Recommendation Report for Planning Permission for Works or Extension to a Dwelling

REF NO: F/19/12/

LOCATION: Cornfields
Burndell Road
Yapton

PROPOSAL: Proposed single storey side extension and new dormers to existing roof (resubmission following F/10/12/) (this application is a Dual Parish with Yapton)

Drawing 1230.03
January 2012

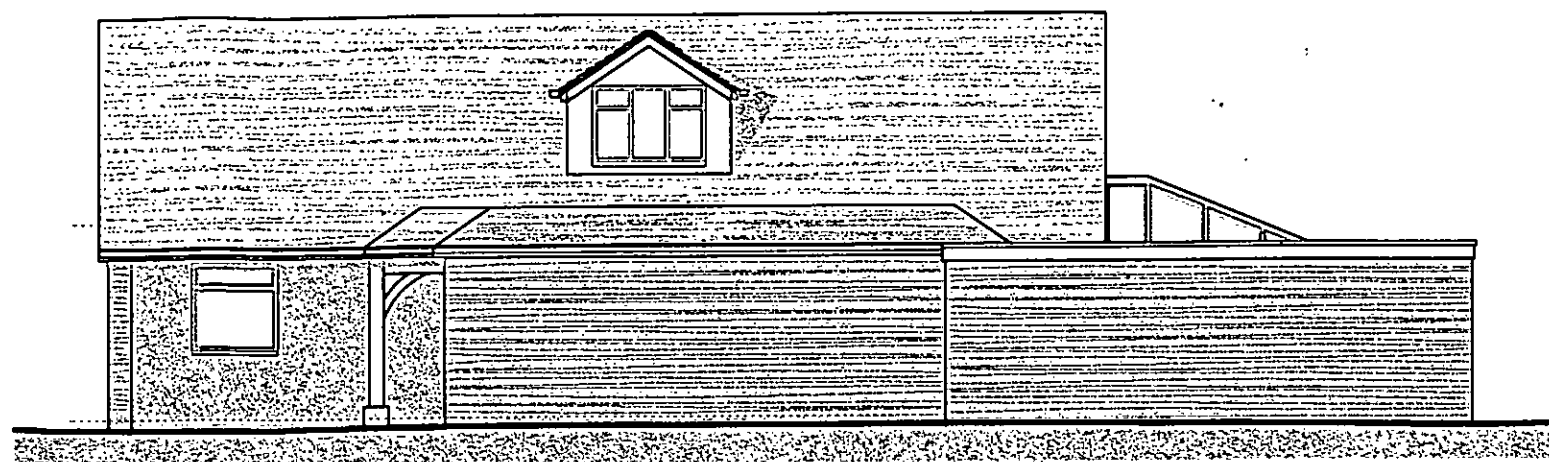
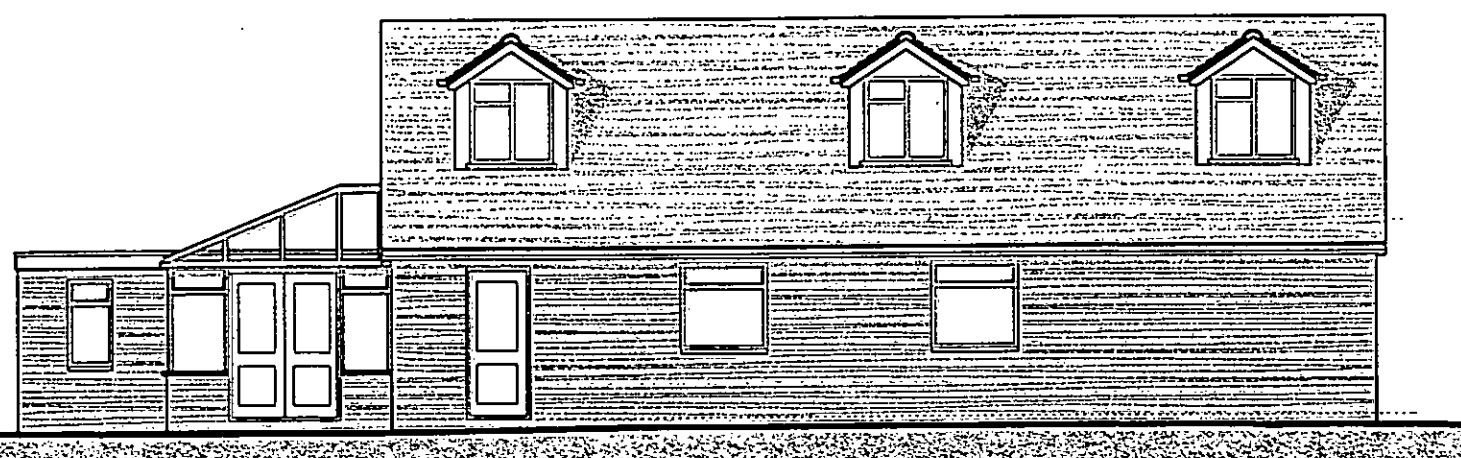
Whilst the windows in the middle and right hand side overlook our roof the window on the left hand side looks straight into our patio thus depriving us of privacy. We have no objection to the style of the windows and have been informed by the applicant that all of the dormer windows will contain frosted glass.

The existing roof space is to be converted into habitable accommodation which will comprise two bedrooms, bathroom, study and store. The proposal has three pitched roof dormers on the eastern side and a single dormer on the western side. To provide additional light into the bedroom a window is proposed to the front at first floor level. The dormers, if approved, will be conditioned to be obscure glazed.

With regard to residential amenity the neighbouring property to the west 'Ferncroft' which is a bungalow has an entrance door and three windows, two of which are obscure glazed on the side elevation fronting Cornfields. Due to the position of these windows the front extension will be set back from these windows and will be partly obscured by the pitched roof garage of Ferncroft which is sited to the boundary. The property to the east Crosswinds is of the same style and design. This property has a lobby which is sited on the western side boundary and two roof lights on the western roof slope. The proposed dormers on this side elevation may have the potential for overlooking onto the rear amenity area of Crosswinds especially the one positioned to the rear. If approved, a condition will be imposed that these be obscure glazed and also the dormer on the western side which serves a study will also be conditioned to be obscure glazed.

- 4 The three dormer windows on the east side elevation and single dormer on the west side elevation shall at all times be glazed with obscured glass.
